Application for Removal or Variation of a Condition following Grant of Planning Permission or Listed Building Consent

DEMOLITION OF EXISTING GARAGE AND ERECTION OF SINGLE STOREY SIDE EXTENSION AND LINK

2022/62/90403/E

Client:	LUMB		
Project:	5 HOPTON HALL LANE		
Drawing Title:	PROPOSED ELEVATIONS		
Stage:	Planning	Status:	S0
Drawn By:	JL	Date:	April 21
Job Number:	2005	Client Project Number:	n/a
Scale:	As Noted	Sheet Size:	A1
Revision:	2005-006		
	P05

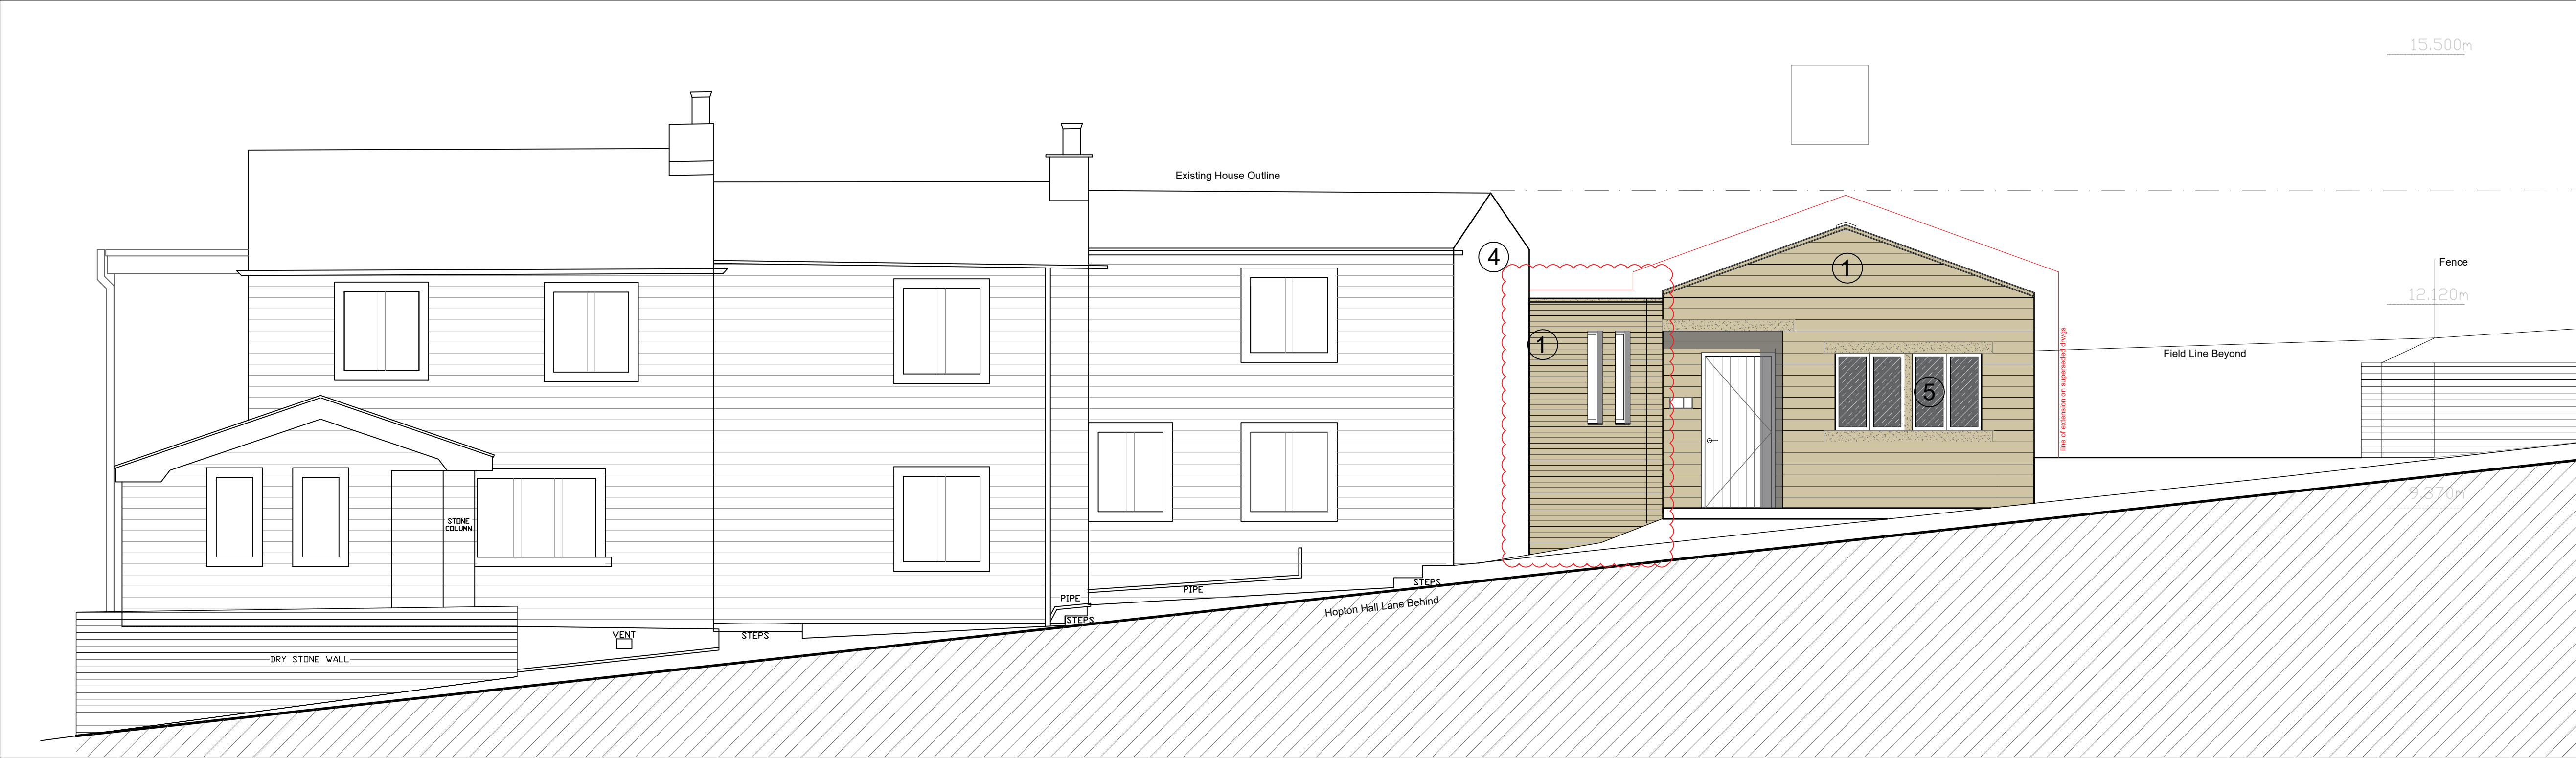
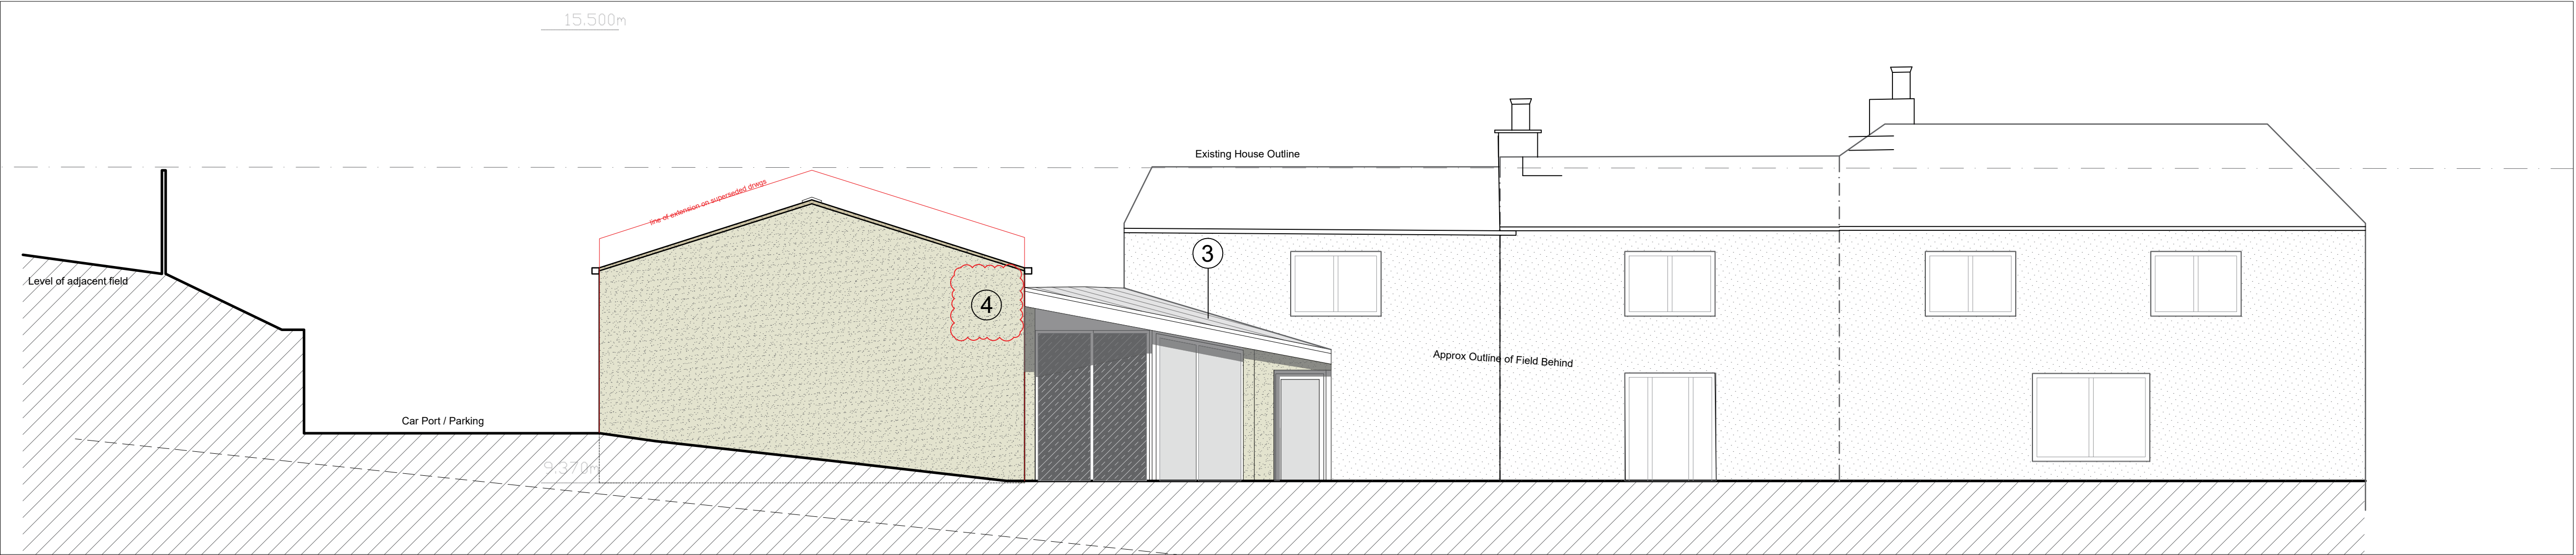
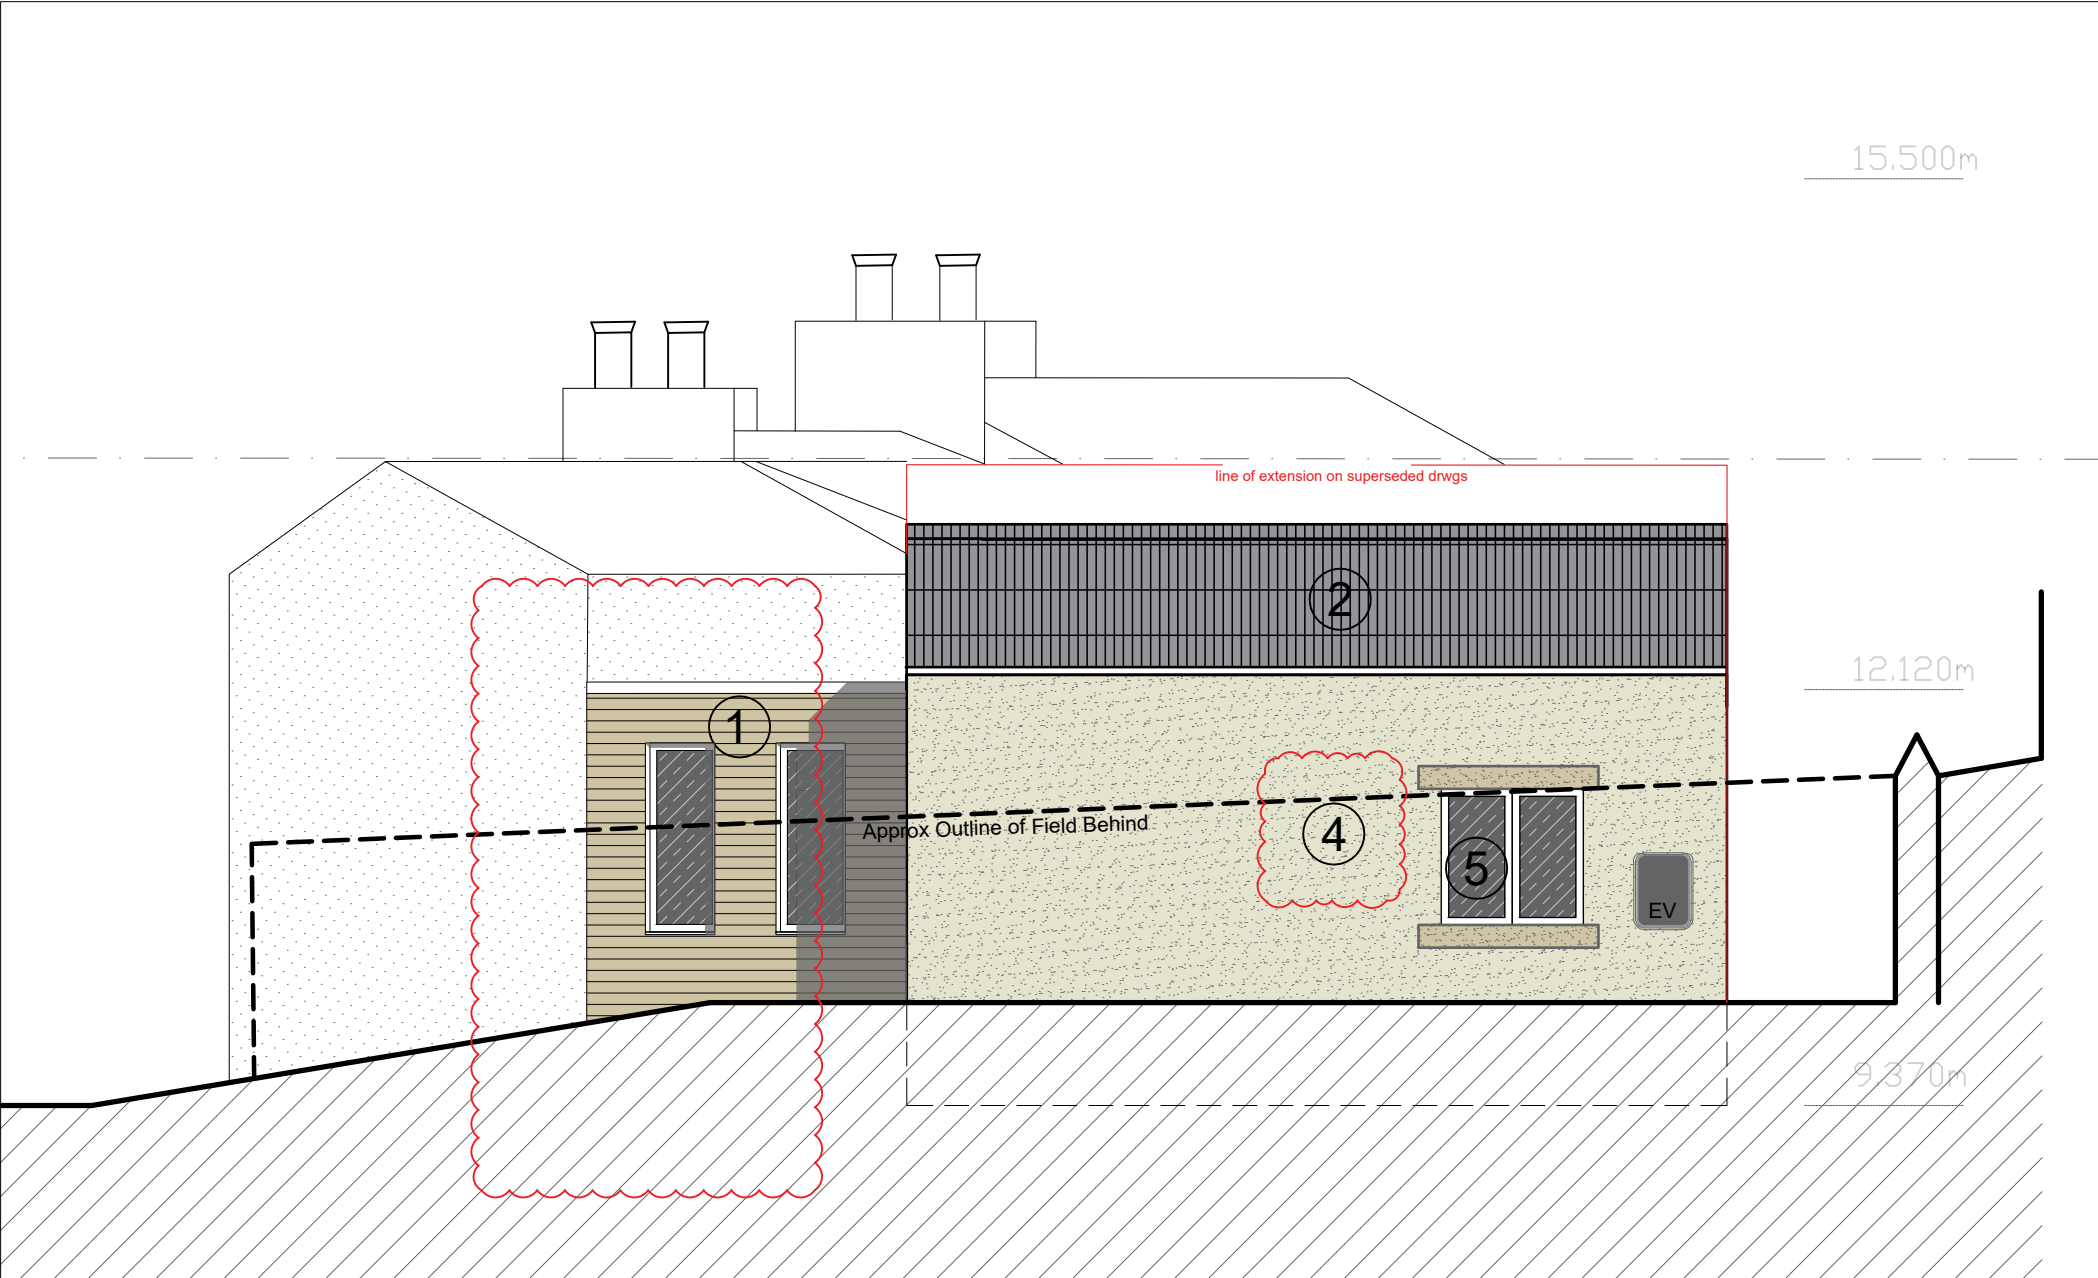
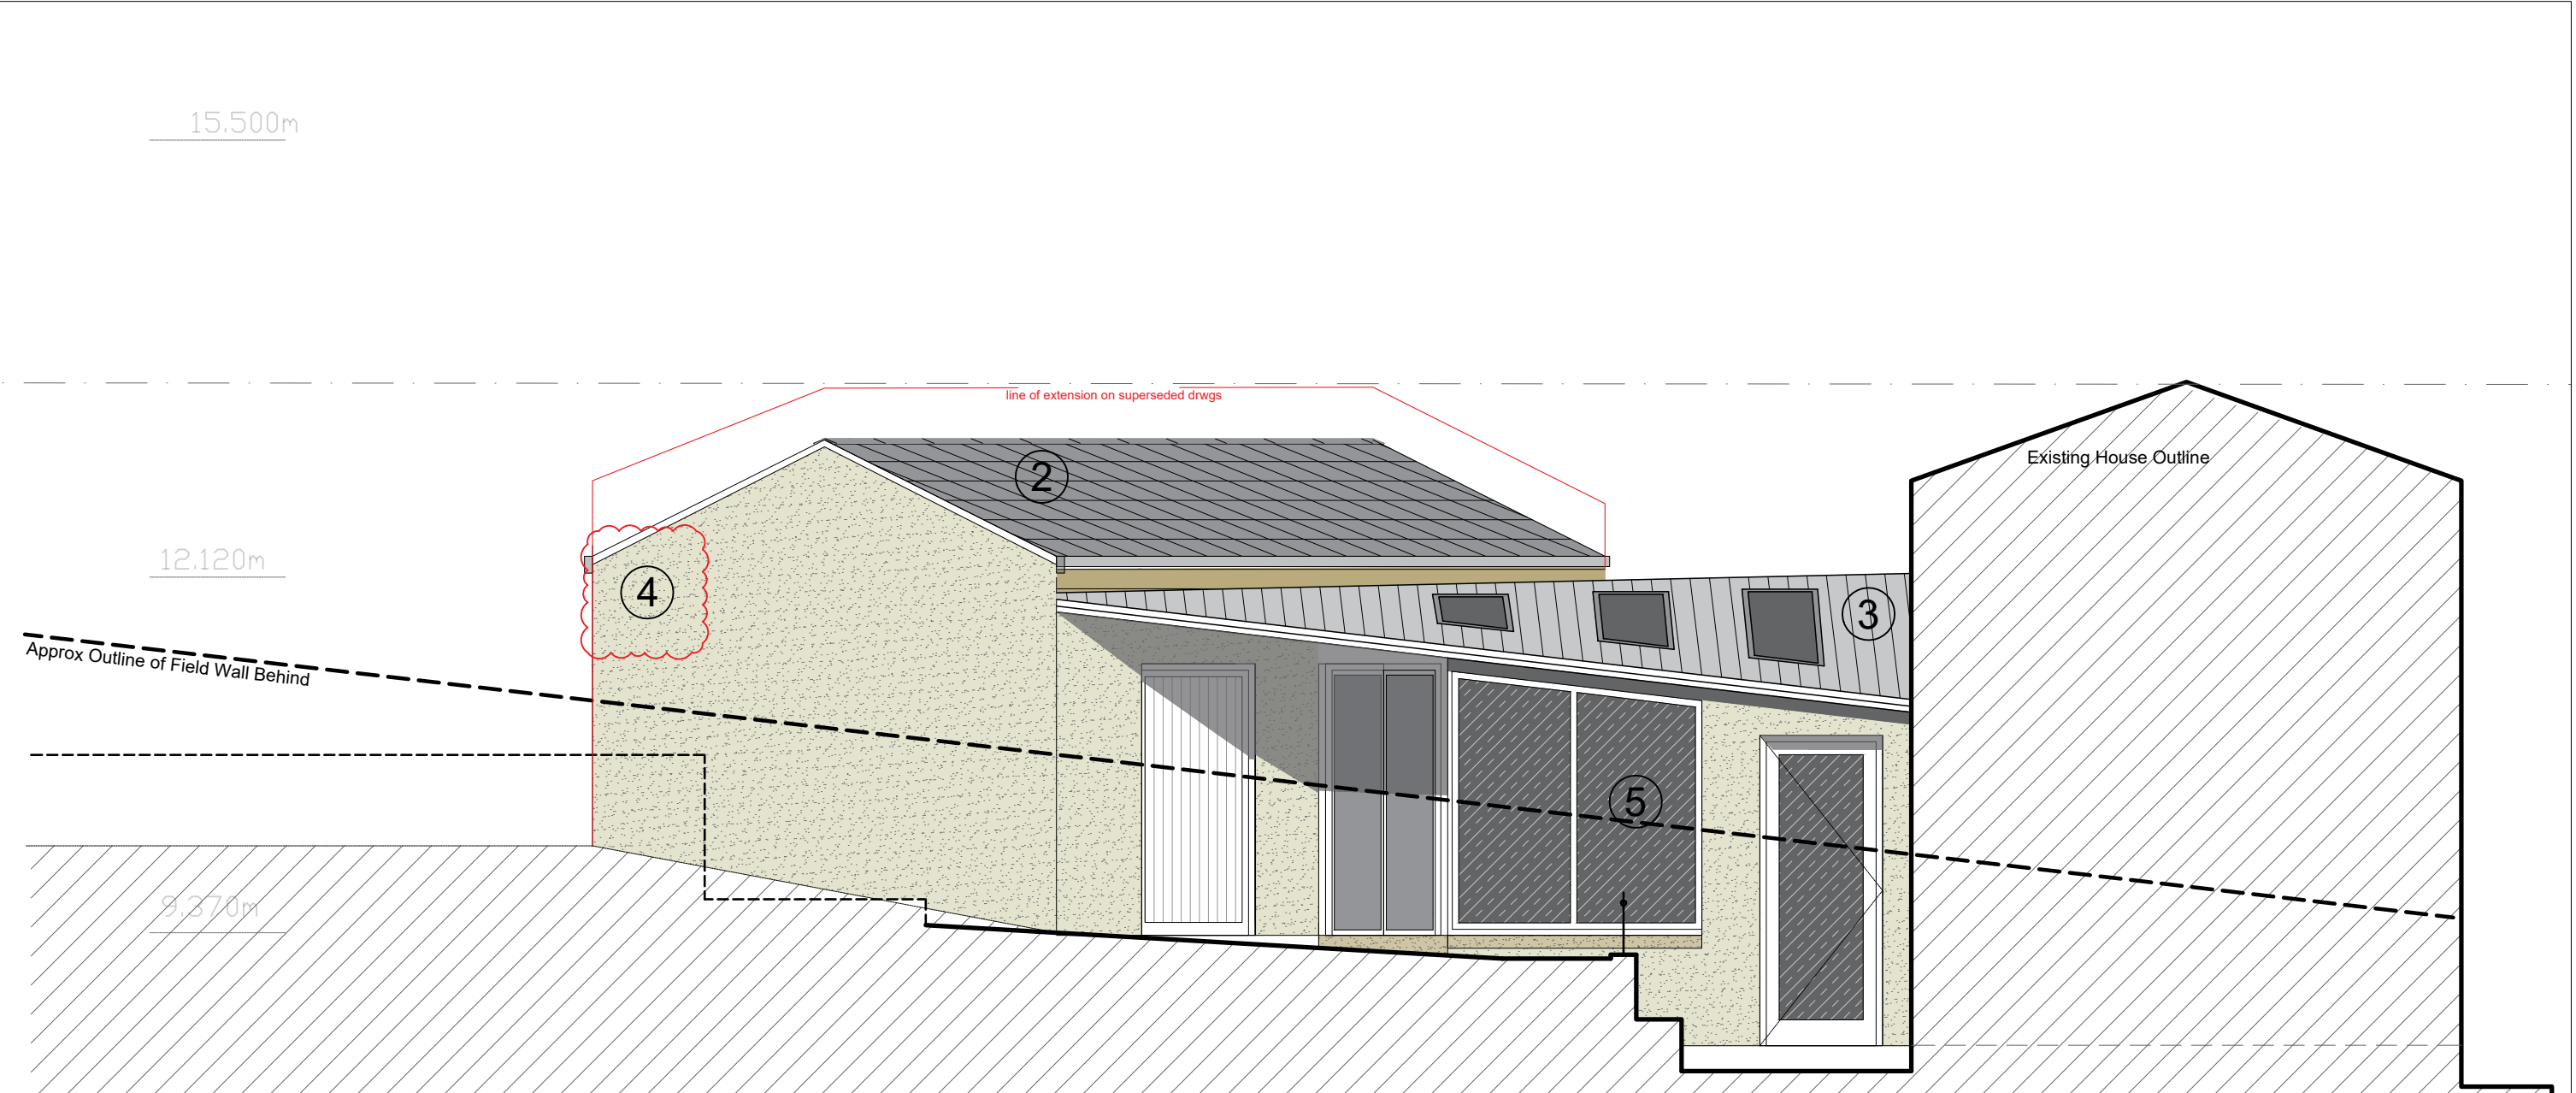
Item 2 - We would like to alter the materials to the rear elevation and partial side elevation from masonry to render.

Item 2 - Upon further consideration and site investigation we feel render will tie in more seamlessly with the existing dwelling house and avoid unnecessary costs on largely unseen elevations. (Locations identified on the appended drawings). There is also the potential to reuse 2no existing walls, which are already rendered.

Please also note that render is already identified on the materials board (Drawing reference - 202005_007_Materials Board) for other small areas of the development.

202005_006_Proposed Elevations_P05
